Recommendation Report for Planning Permission for Works or Extension to a Dwelling

REF NO: AW/48/19/HH

LOCATION: 11 Chawkmare Coppice
Aldwick
PO21 3BU

PROPOSAL: Rear two storey and single storey extension to existing residential dwelling (resubmission)

PROPOSED FIRST FLOOR PLAN

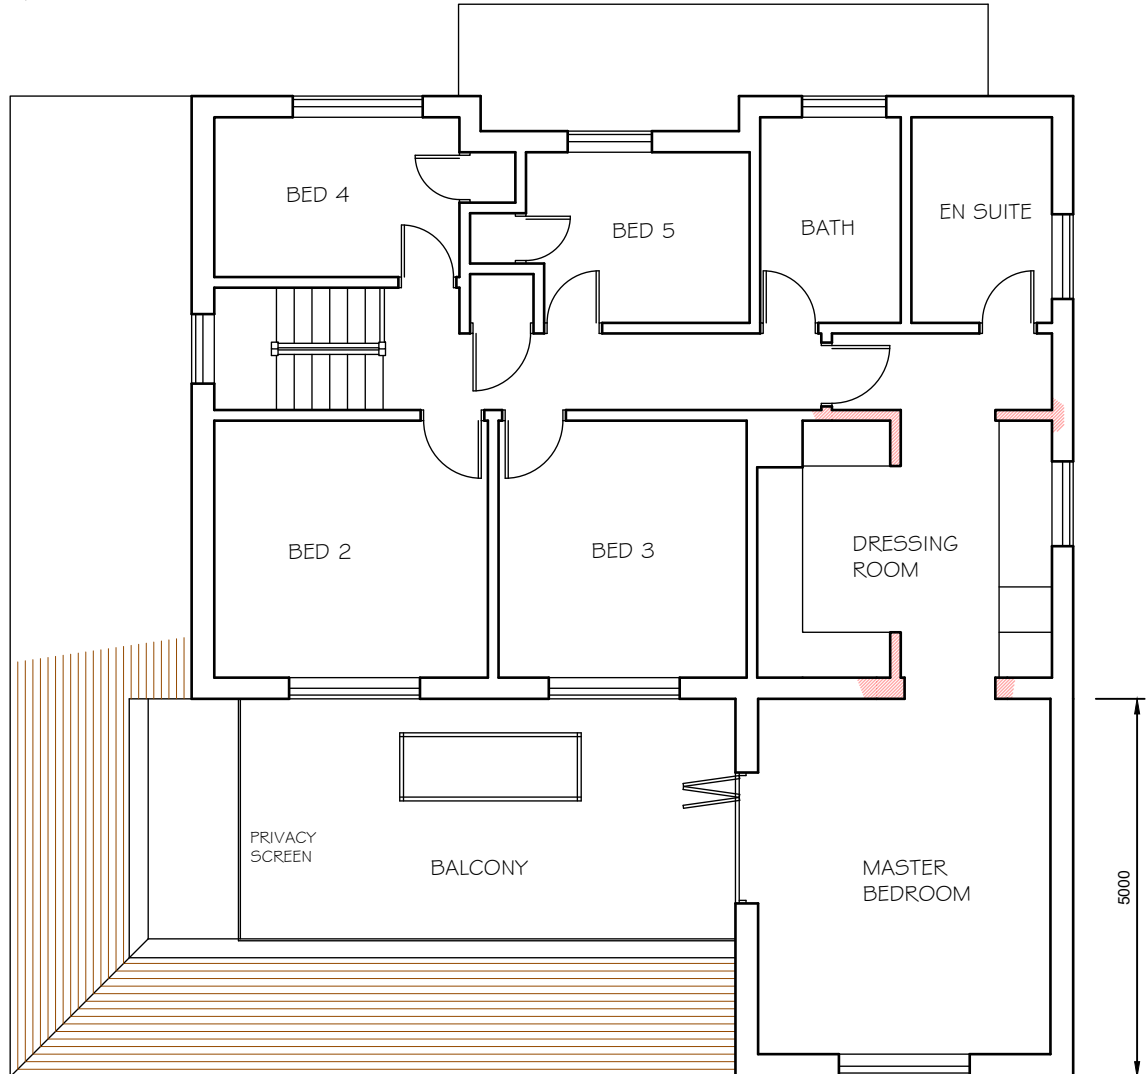
The proposal seeks to alter the rear elevation of the dwelling from that which was previously approved by increasing the depth by 1.5m at single storey level. This will extend to meet in line with the proposed two storey extension. Due to the siting the increase in depth is not considered to give rise to any additional adverse overshadowing or overbearing with the separation of 1.6m retained to the west. The height will remain as existing however the roof of the extension will be used as a balcony.

A window will also be replaced with a door on the western side of the two storey extension to allow access to the balcony. This alteration is not considered to give rise to any additional adverse impacts upon neighbouring amenity with the privacy screen again mitigating any overlooking achievable to the west. There are no properties to the rear and due to the siting of the dwelling and extension, the balcony is not considered to give rise to any adverse impacts upon the neighbours to the east.

PROPOSED NORTH (FRONT) ELEVATION

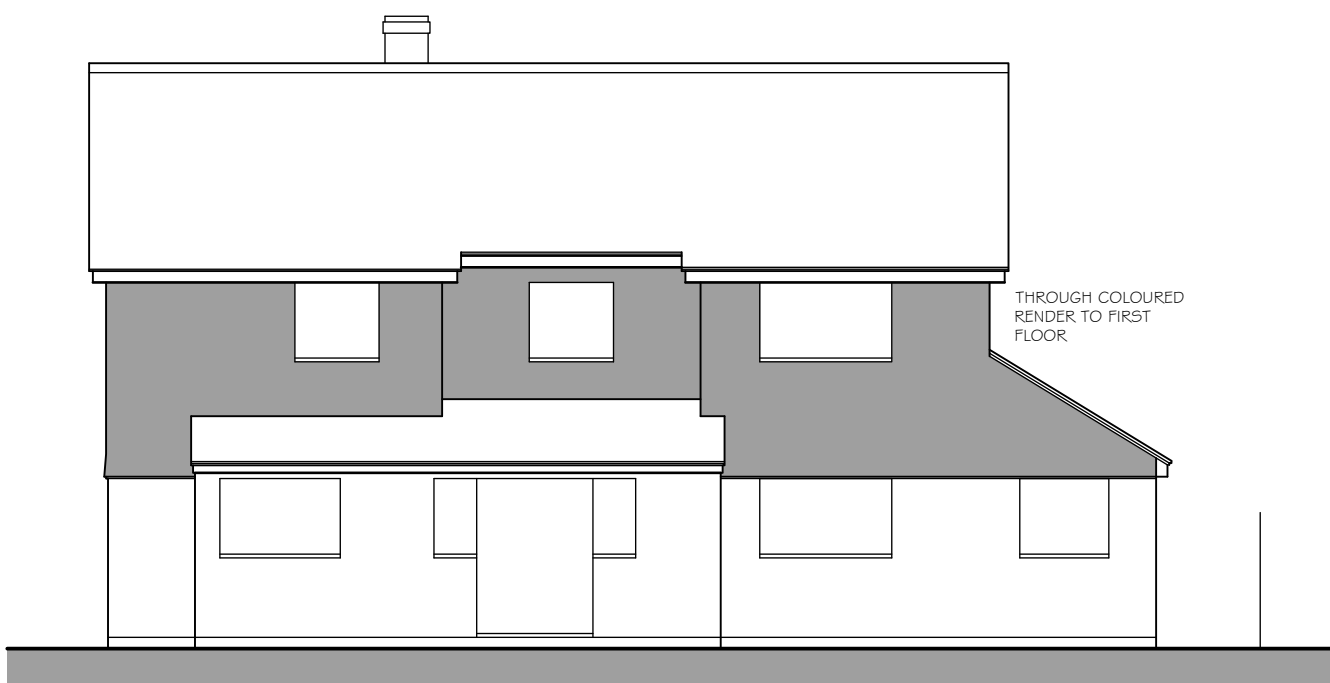
The alteration of first floor material to the external elevations of the dwelling will be visible from the street

scene. The application proposes a light grey render as opposed to the cladding originally approved. It is not considered this alteration would prevent the proposal from being in keeping with the area with the surrounding properties comprising a varied style and design.

PROPOSED WEST (SIDE) ELEVATION

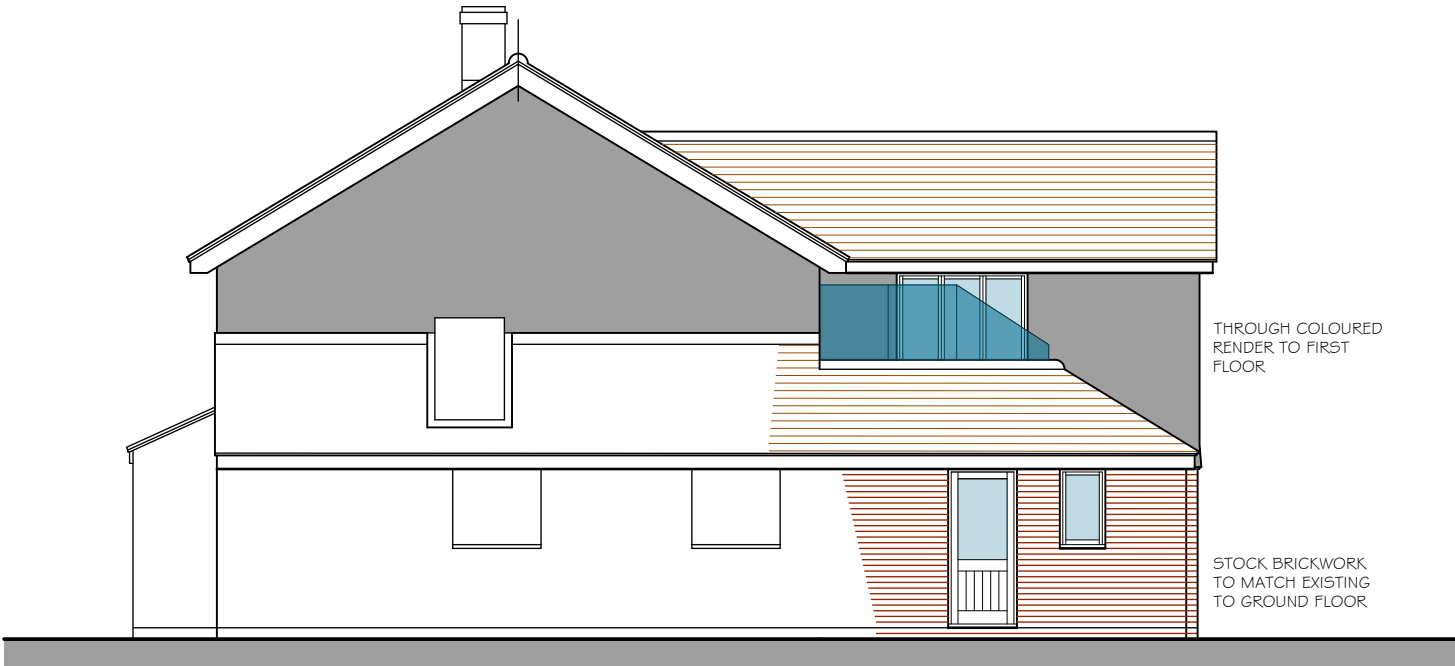
There will be a privacy screen constructed to the western elevation to mitigate against any potential overlooking that may be possible towards the neighbouring property at this elevation. This will be conditioned.

To the western ground floor an additional window will be constructed however this again is not considered to give rise to any additional overlooking impacts with sufficient boundary treatment in place also.

- 4 The balcony screening on the west elevation of the first floor balcony extension shall at all times be obscured glazed and to a height of 1.7m from finished floor level and retained thereafter in perpetuity.
Reasons: In the interests of the amenity of the neighbouring dwelling in accordance with policies DDM1 of the Arun Local Plan.
